From: Geoff Gibbs [REDACTED]
Sent: 20 November 2020 12:37
To: Planning <Planning@arun.gov.uk>; Michael Eastham <Michael.Eastham@arun.gov.uk>
Subject: A/179/20/RES Land South of Water Lane, Angmering, Approval of reserved matters etc.

A/179/20/RES Land South of Water Lane Angmering Approval of reserved matters (appearance, layout & scale of access only) following A/99/17/OUT for a culvert & associated access over the Black Ditch providing access to the approved development. This application may affect the setting of a listed building & falls within Strategic Site SD9, CIL Zone 1 (Zero Rated).

WATER LANE, ANGMERING
PROPOSED ACCESS
VEHICLE SWEEP PATH ANALYSIS
DUO RECYCLER

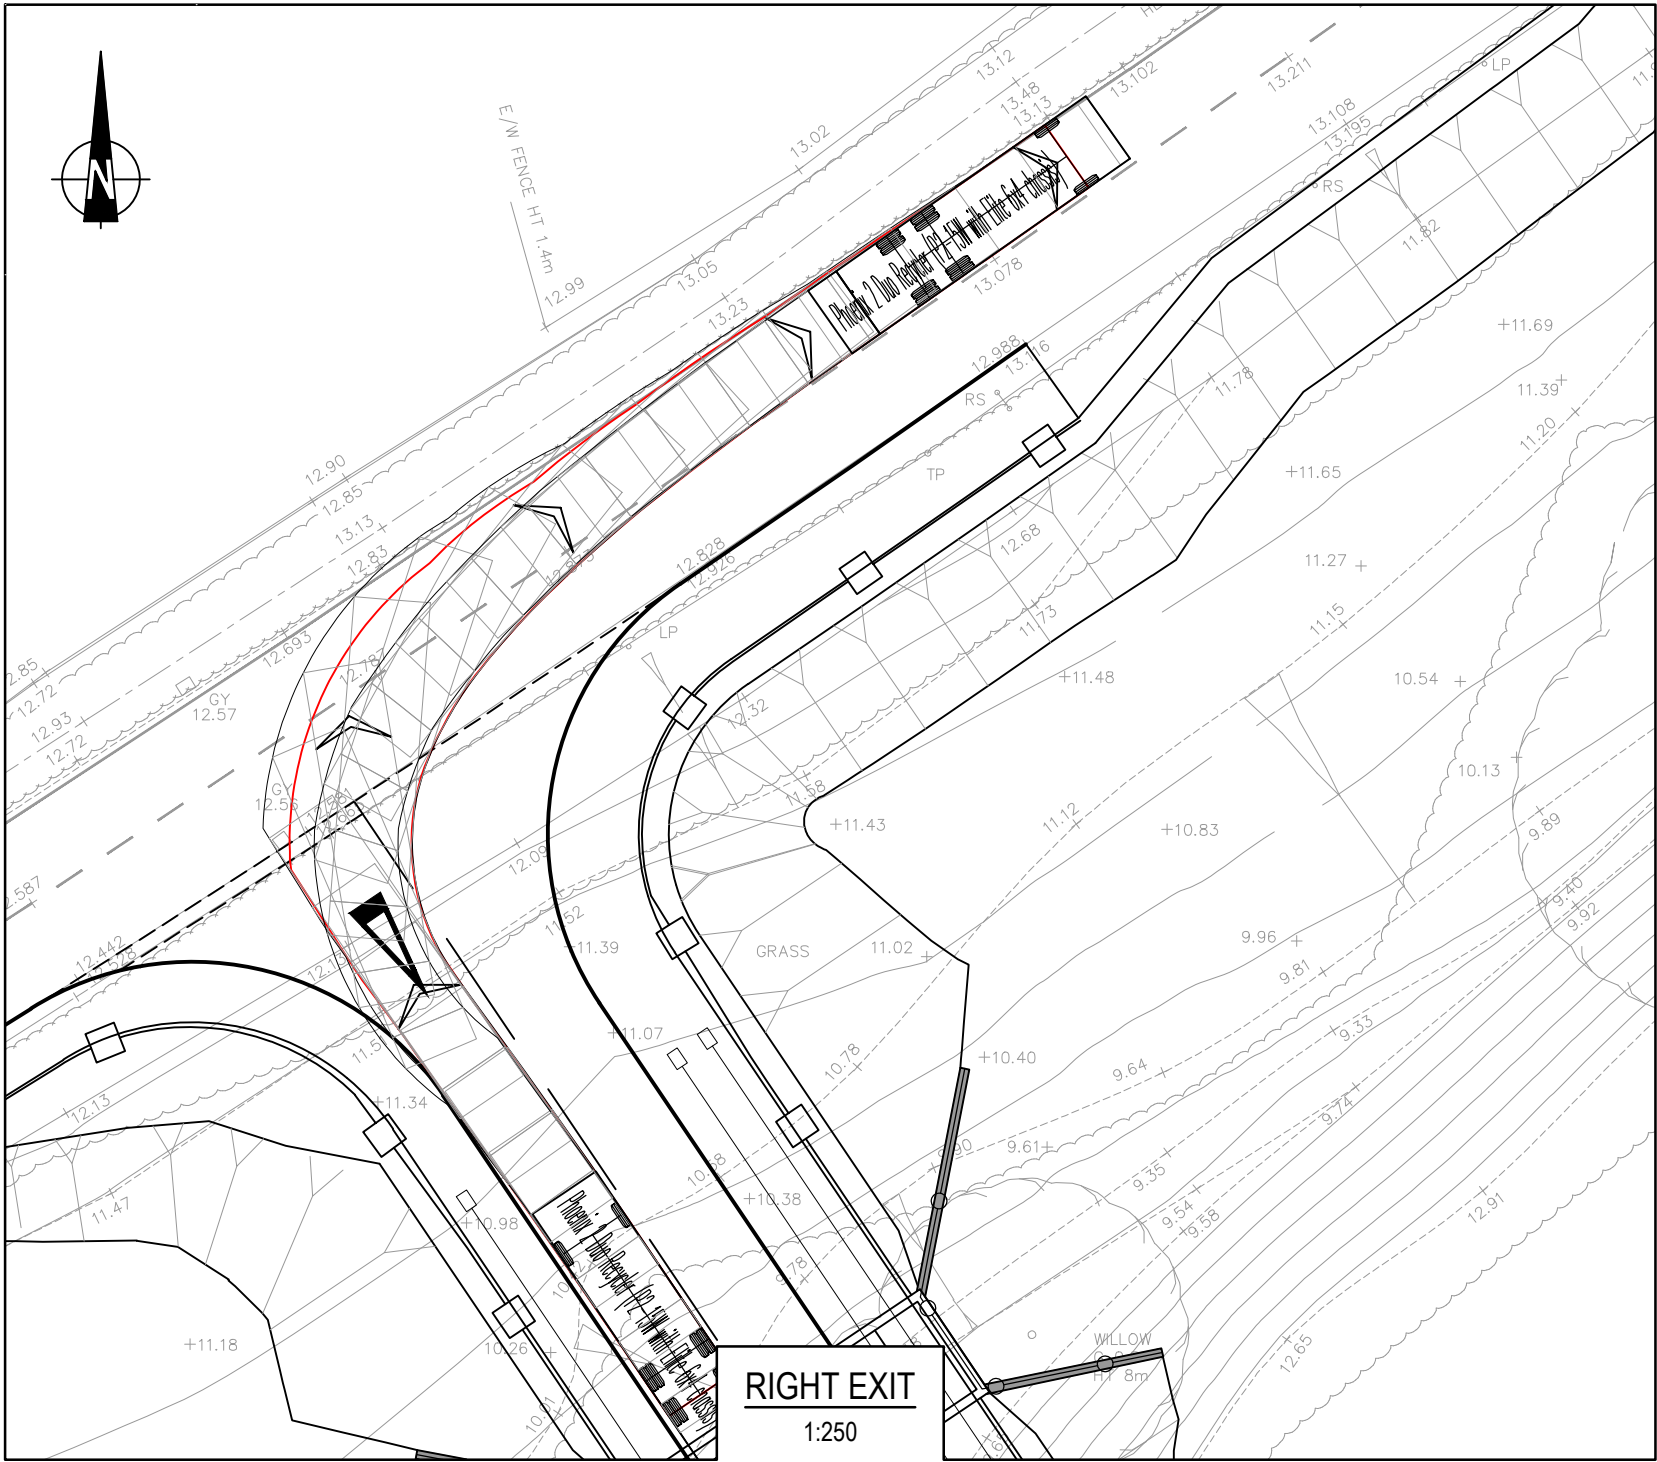
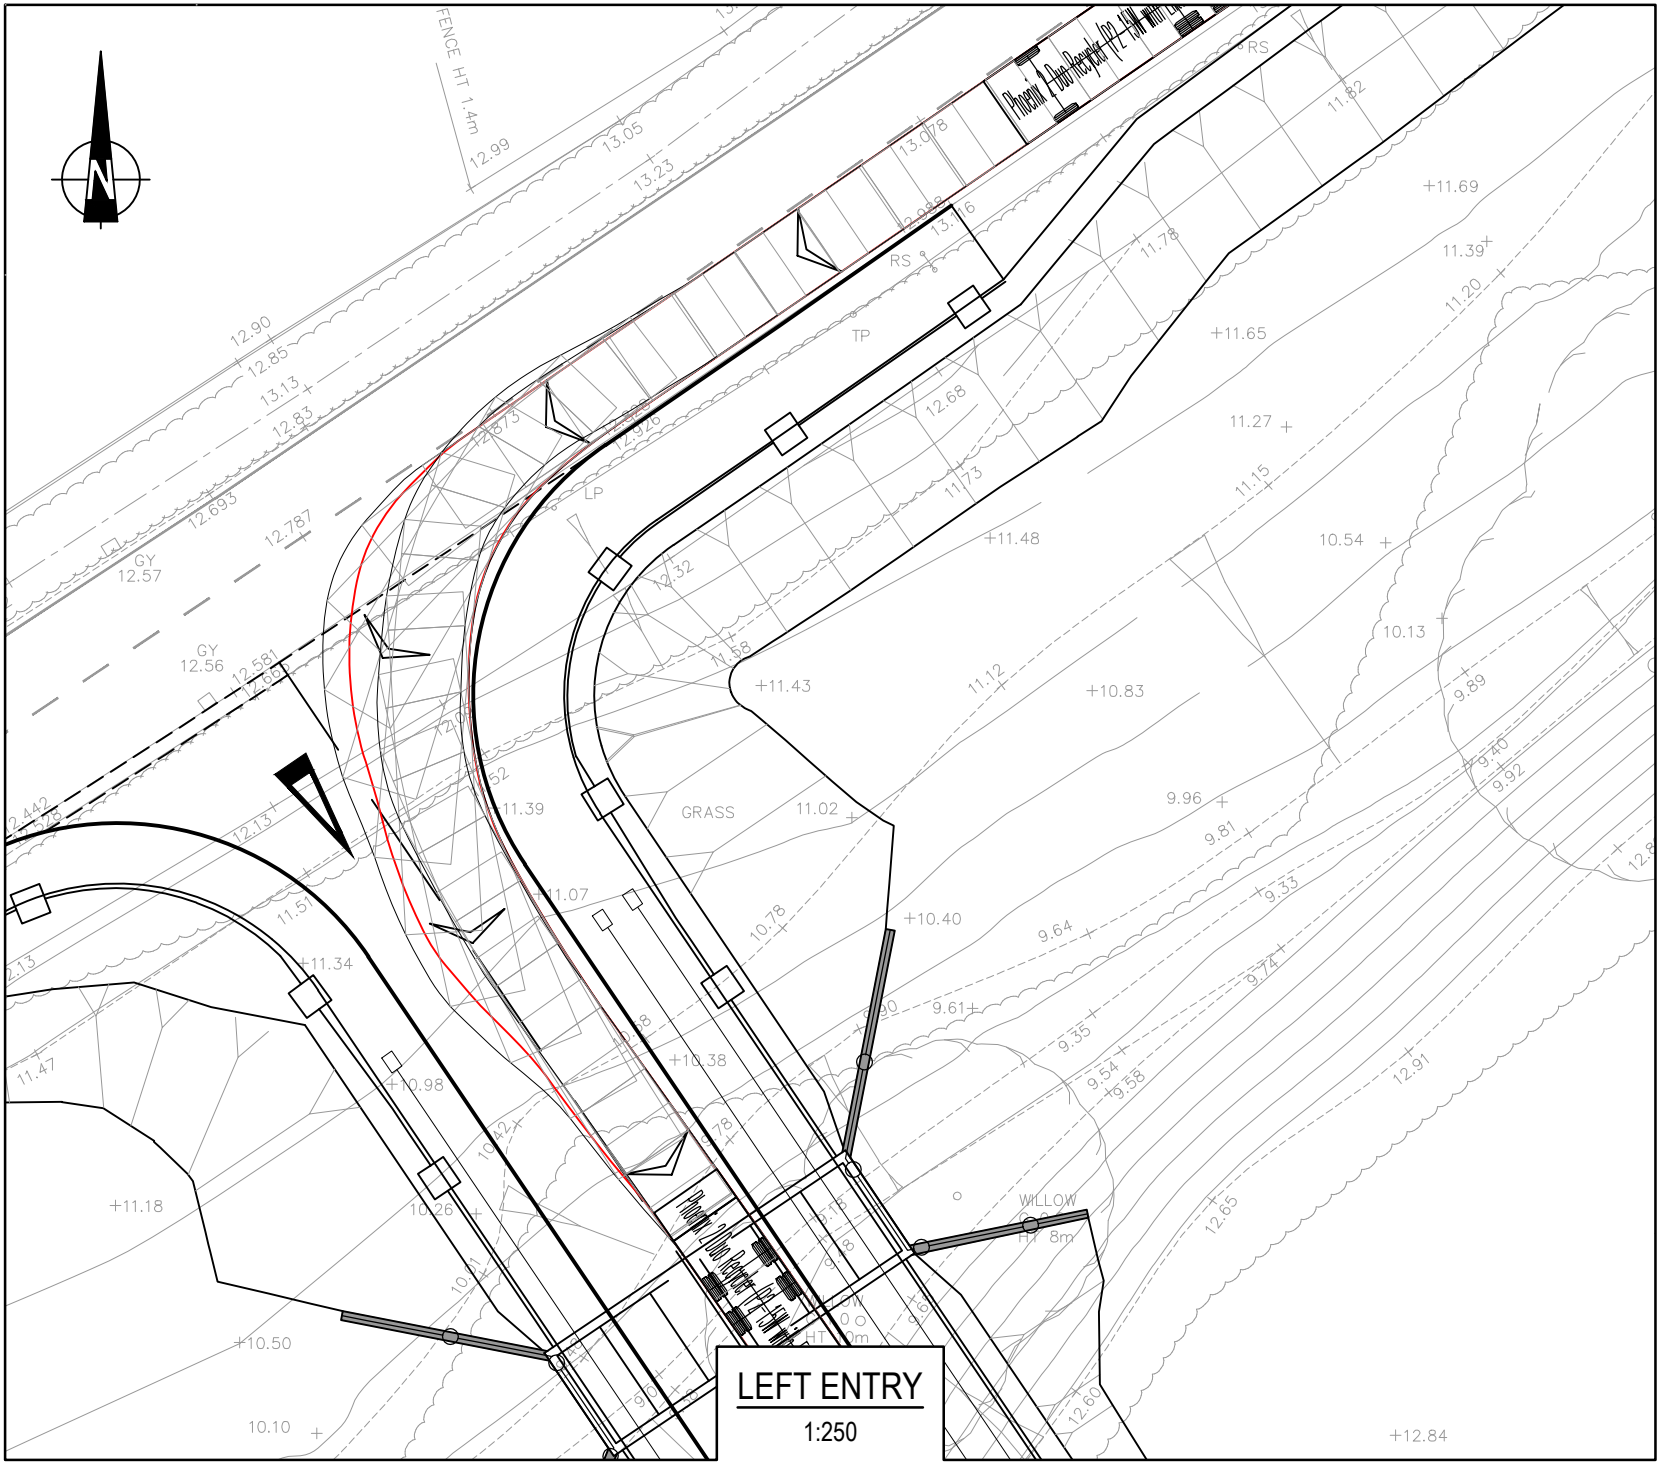
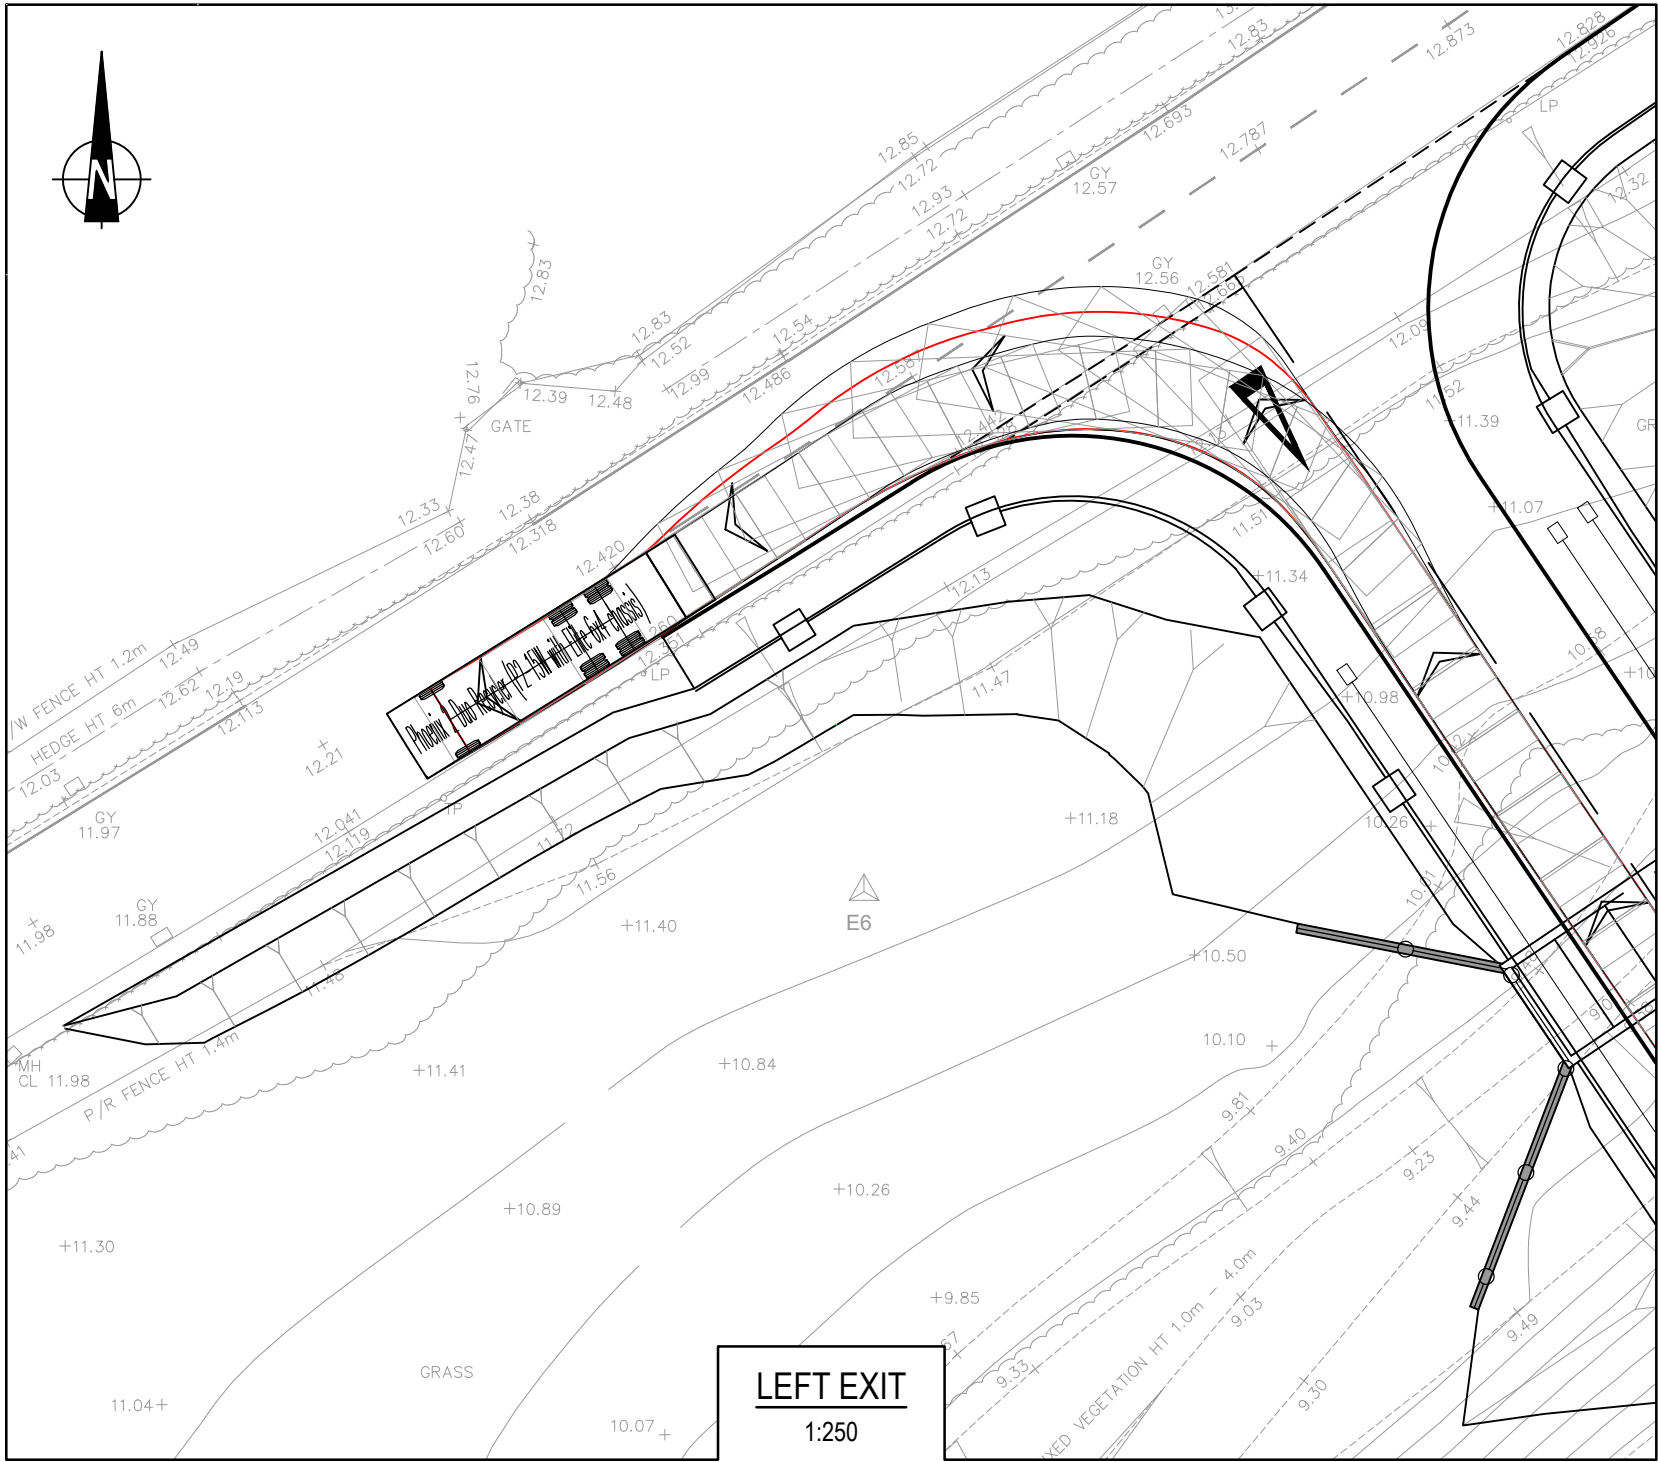
I write to object to the proposal for a temporary access to the development site for construction purposes from the eastern end of High Street. The use of the narrow High Street for this particular site is entirely inappropriate because it is simply unnecessary.

A 'construction management plan' dated 28th October 2020 was posted on your website on 29th October 2020 but quickly replaced on 13th November 2020 with a substitute 'construction management plan' dated 9th November 2020. The most significant aspect of this 'plan' is the proposal to use a narrow site access at the eastern end of the similarly narrow High Street for construction purposes for the early part of the construction phase. The early part of developing any housing site requires a disproportionately large number of vehicle movements and particularly much larger vehicles. This, as civil engineers know, is because the early part of the construction period involves building highway and drainage infrastructure and here this includes a permanent crossing of the Black Ditch.

It is unclear what access alternatives were considered because none were documented. It seems obvious that there should be a temporary construction access to the site from Water Lane some distance to the east of the proposed site access. Water Lane in this area, unlike High Street, has limited frontage access and is rather wider. A competent contractor could easily and safely cross the Black Ditch with a temporary access.

If you are minded to approve this temporary access off High Street will you please consider carefully its impact on walkers? Besides High Street leading to the footbridge over the A280 'bypass' the eastern end of High Street connects with a southbound track that joins with Cow Lane which, I believe, is a restricted byway.
